## KITTITAS COUNTY COMMUNITY DEVELOPMENT SERVICES

**RE: Transmittal of Comments – Porter-Matthews Short Plat Amendment (SP-18-00005)**

SUBJECT: Porter-Matthews Short Plat

Hazardous Slopes

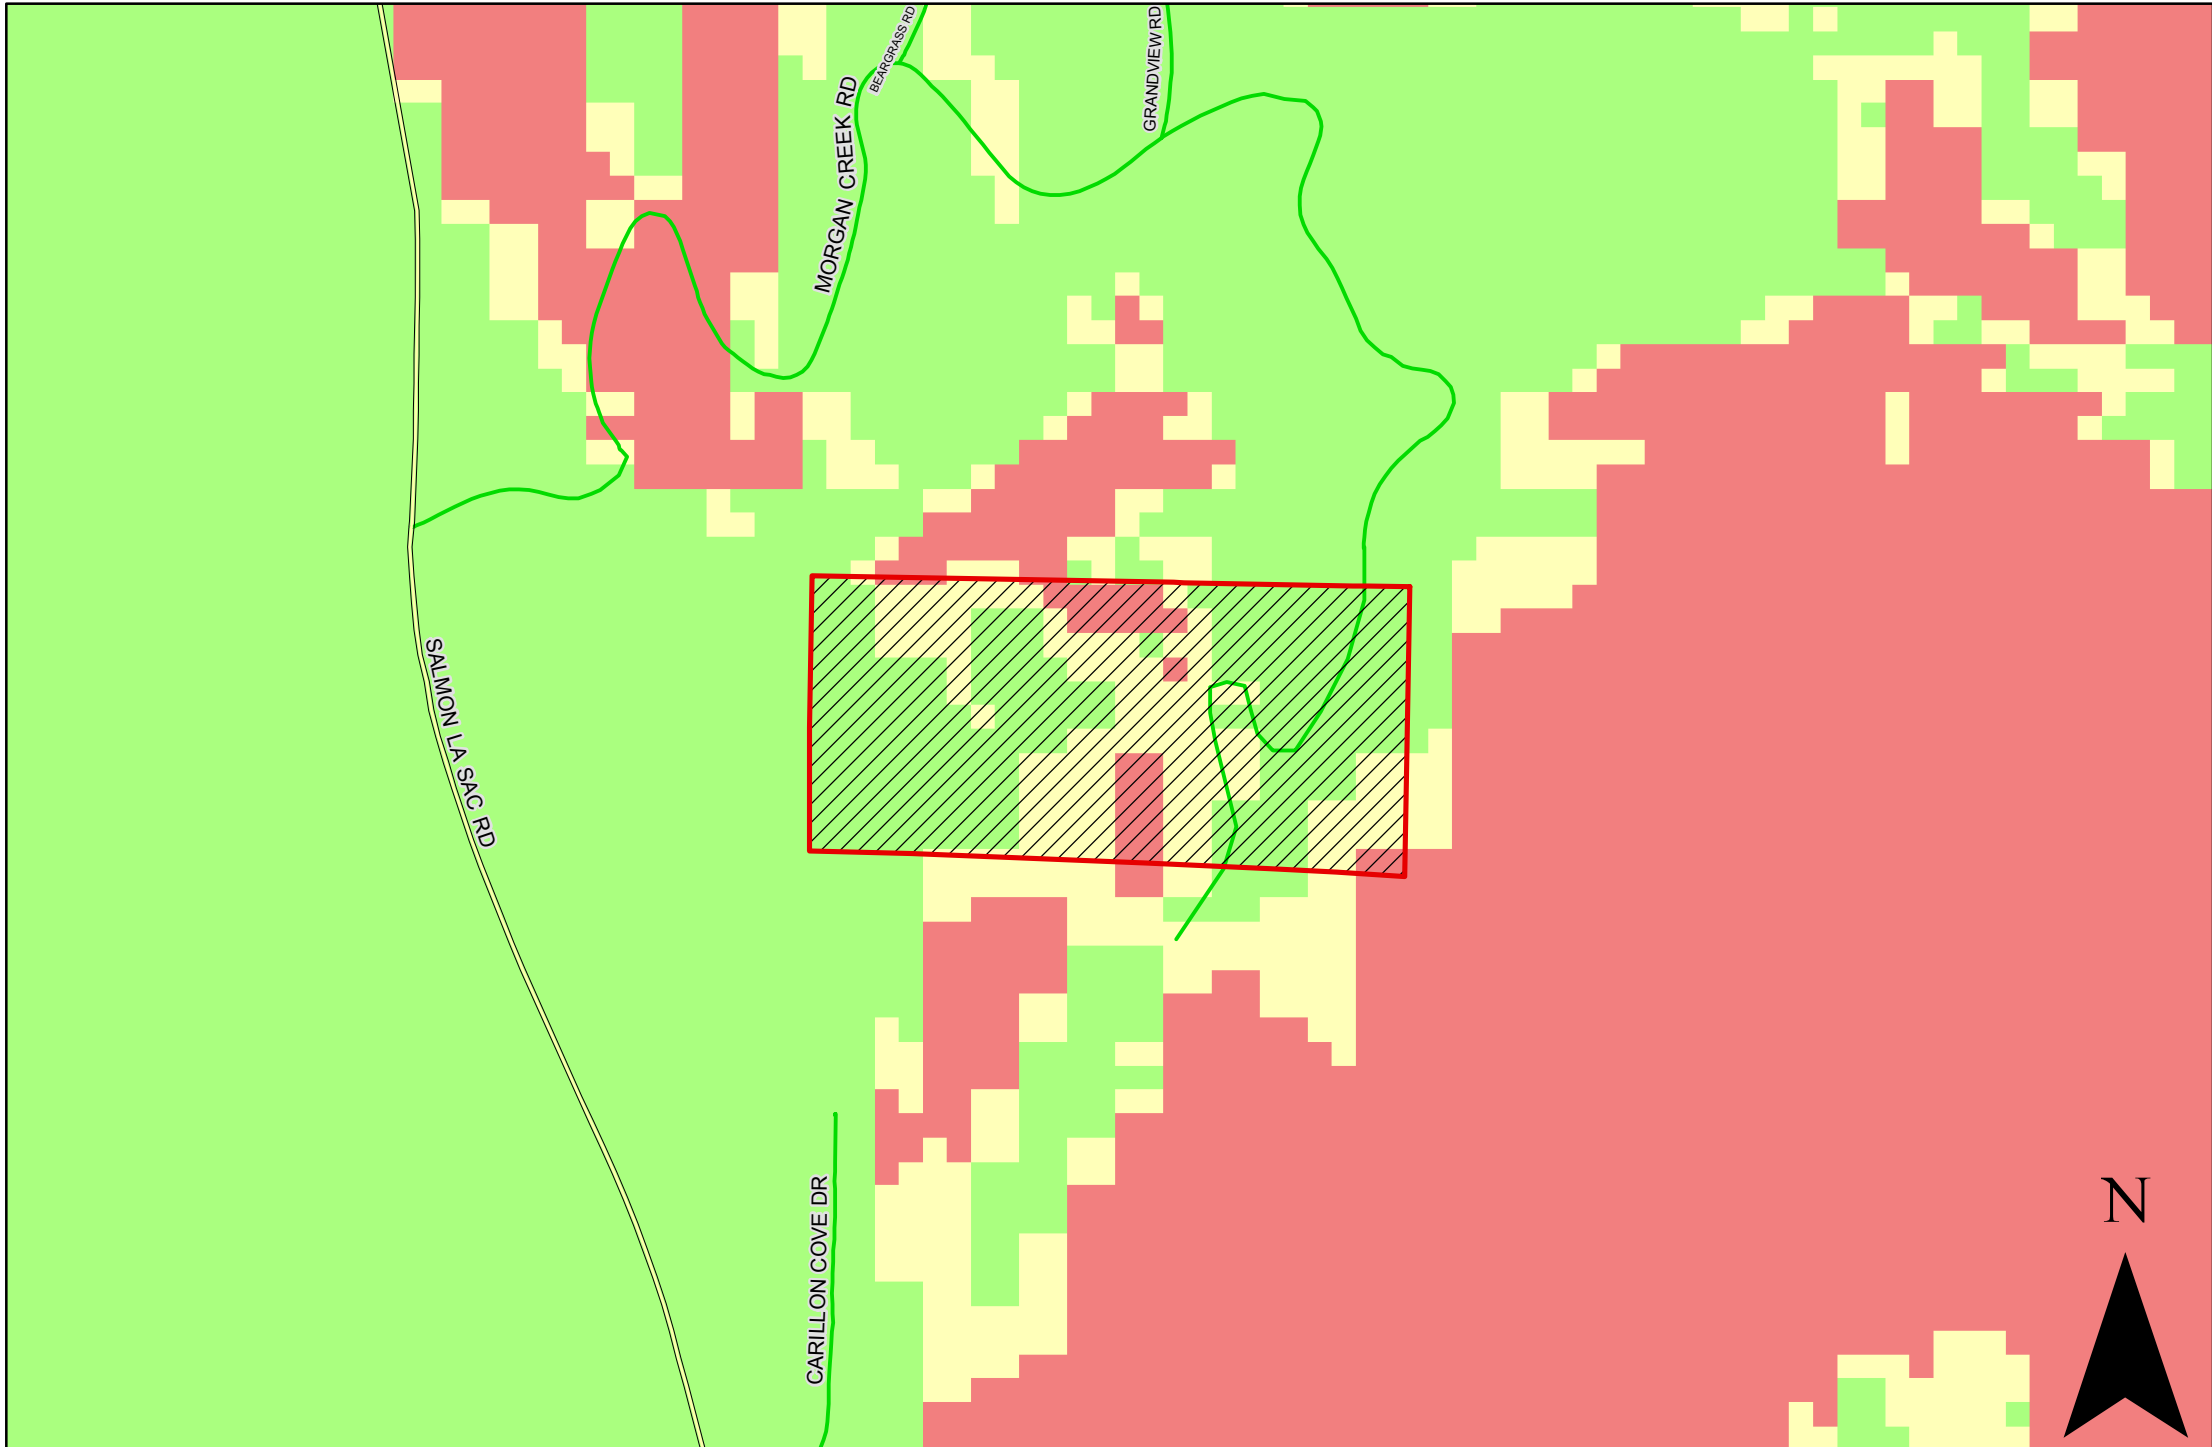
This is very steep terrain. During the Jolly Mountain fire crews had a difficult time making access some of the larger apparatus could not be used due to the steep grade. WUI must be followed. The county road standard or the IFC access requirements must be met, which ever one provides for a higher level of safety. This appears to be a dead end road creating a potential trap for residents and emergency crews, a secondary access should be provided. Fire flow appears to be non-existent. This is a dangerous combination that will place future residents and firefighters in unnecessary danger. No exemptions to the fire code, WUI or road standards should be granted. Contact me if you have any comments or questions. Thank you.

We have learned in the winter time access can be severely impaired when ice conditions affect the roadway because of the steep slope making it extremely hazardous for firefighters. Additionally, lack of an improved water system makes firefighting difficult.
